Rezoning Transportation Analysis

Petition Number: 2023-007

General Location Identifier: 21705118, 21705199, 21705127, and 21705104

Date	Description
05-23-2023	First Review (JP)
06-21-2023	Second Review (DR)
07-10-2023	Third Review (DR)

SHEET TITLE
REZONING PLAN: PETITION # 2023-007

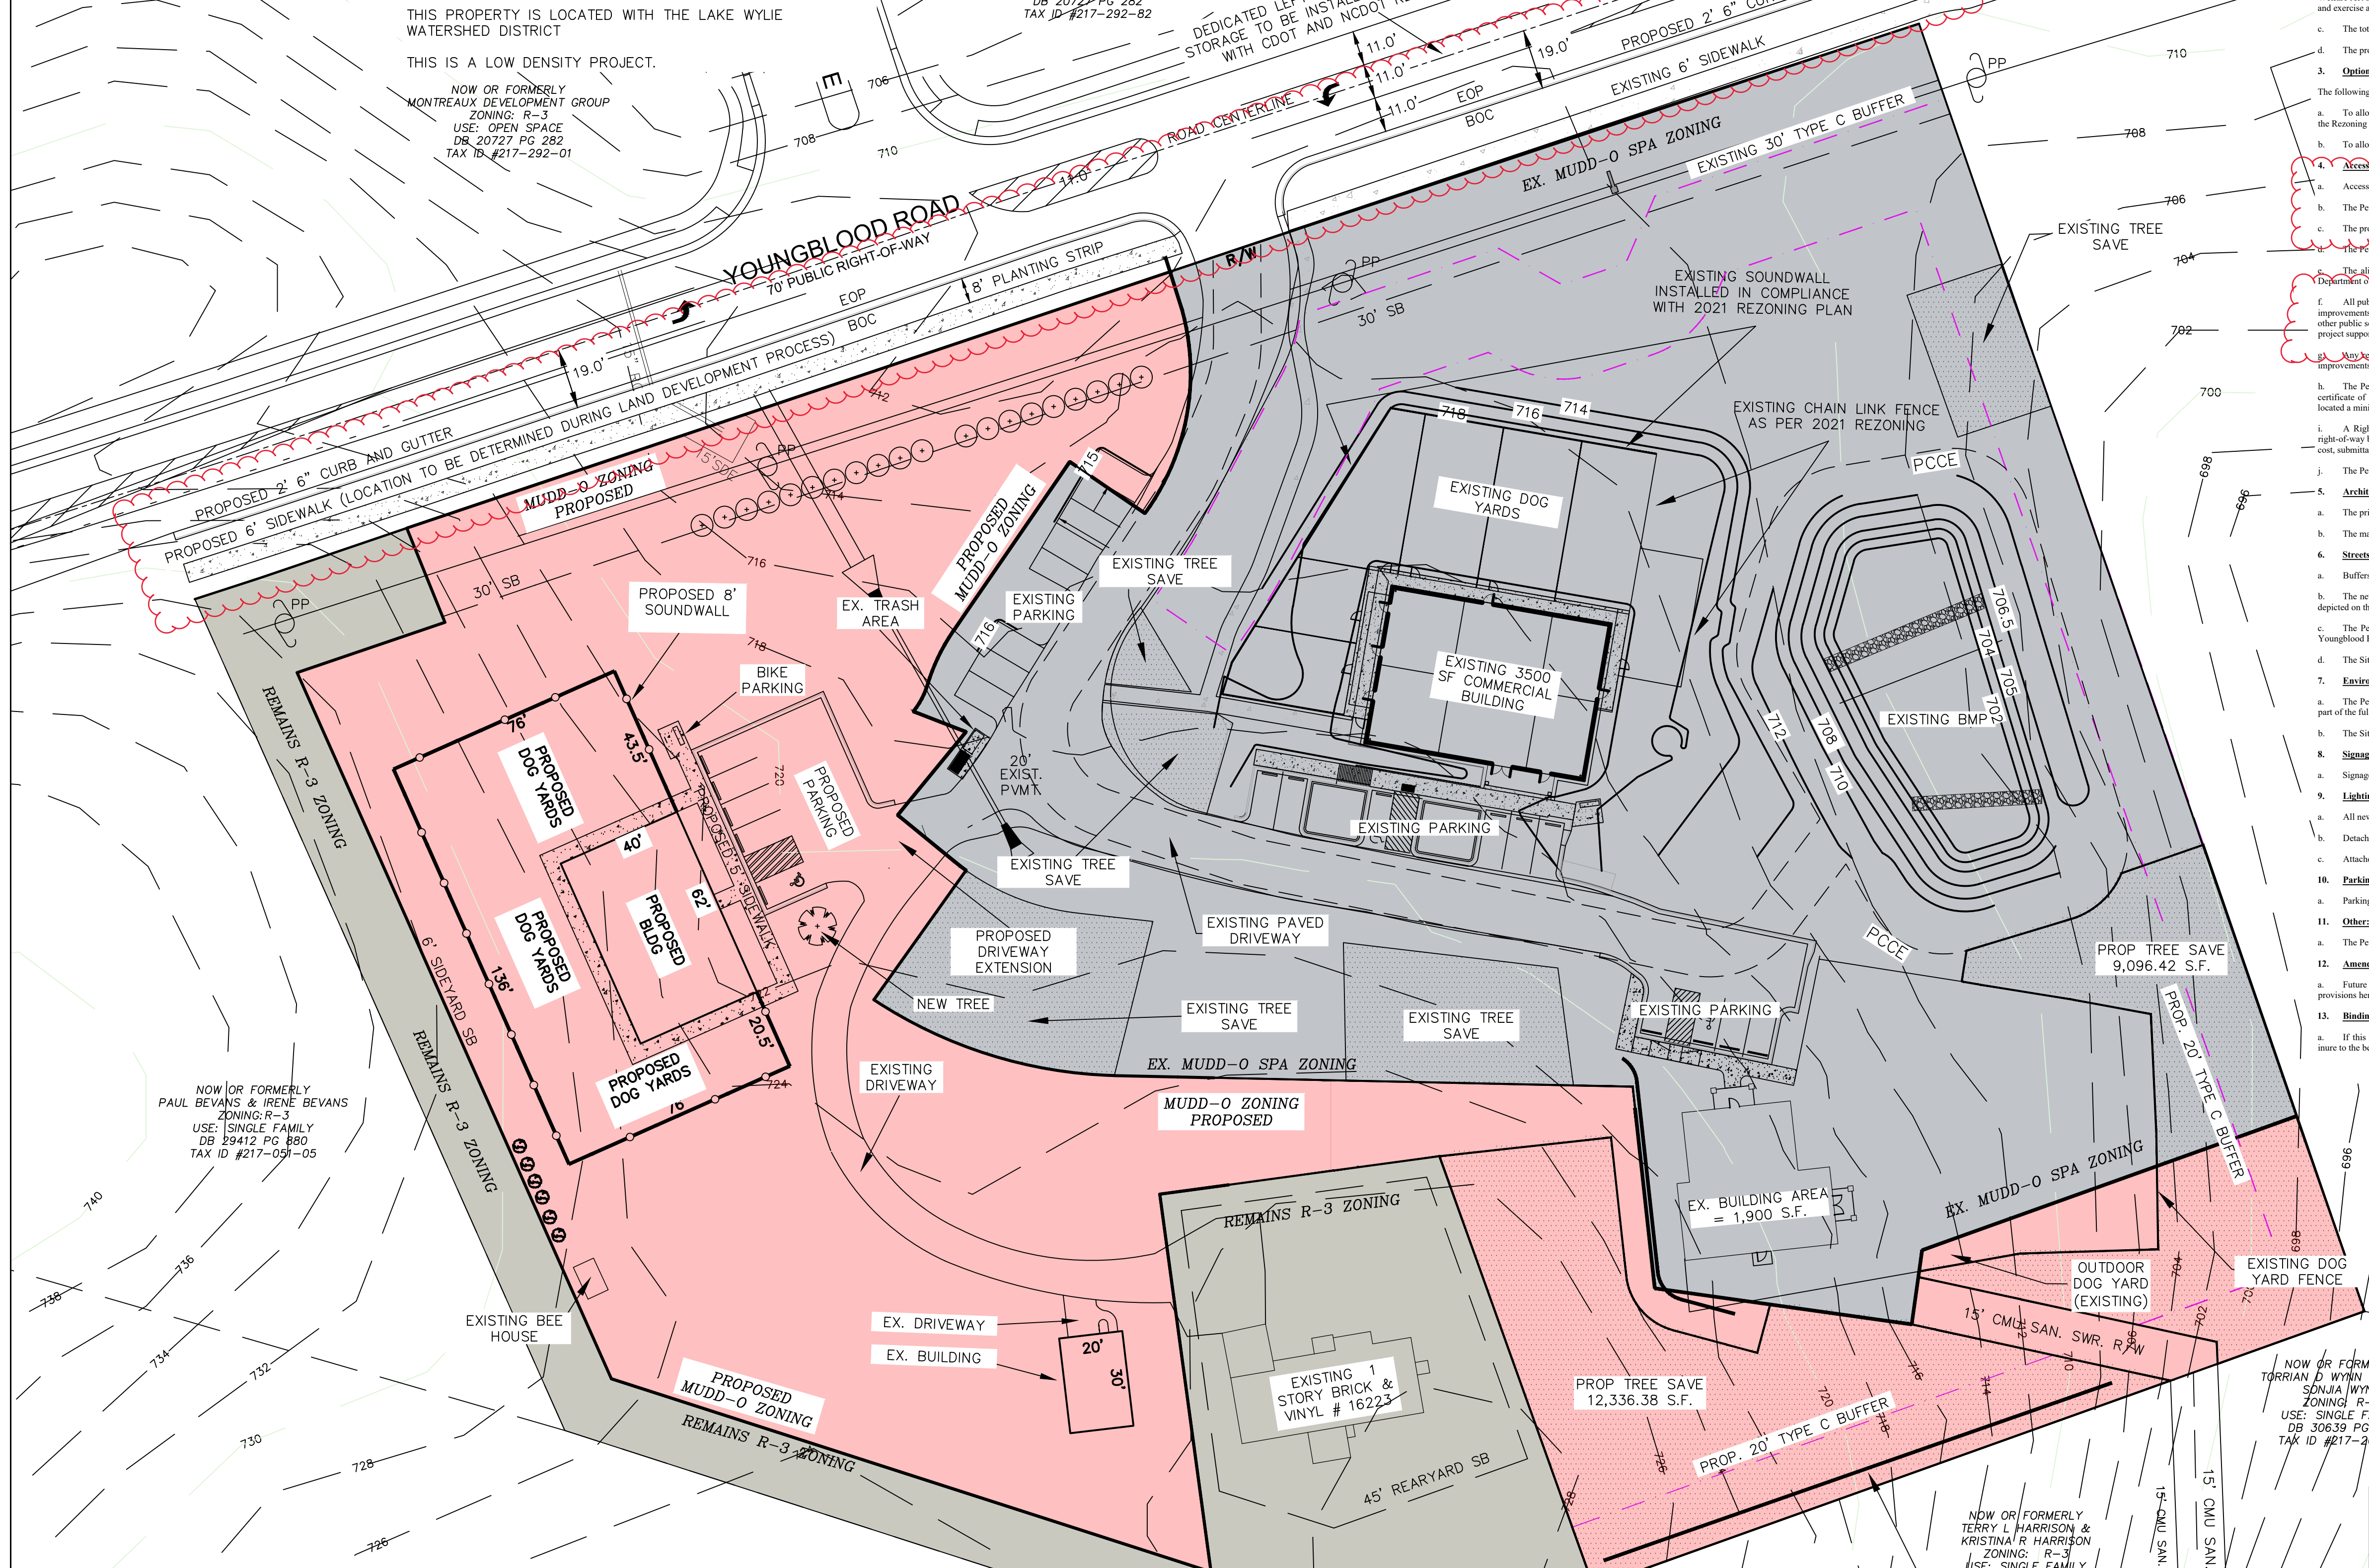
- Youngblood Road:** Location of curb and gutter to be moved to 19 feet from roadway centerline to accommodate the Charlotte Streets Map with a roadway typical section of a 2+ avenue with an 8-foot planting strip and a 12-foot multi-use path.

Label and dimension the curb and gutter from the centerline for each road on the site plan.

Clarifying comment 6.21.2023: Label and dimension back of curb from the roadway centerline of Youngblood Road.

Clarifying comment 6.21.2023: Revise conditional note to ensure restripe is spelled correctly.

Clarifying comment 6.21.2023: Add conditional note.
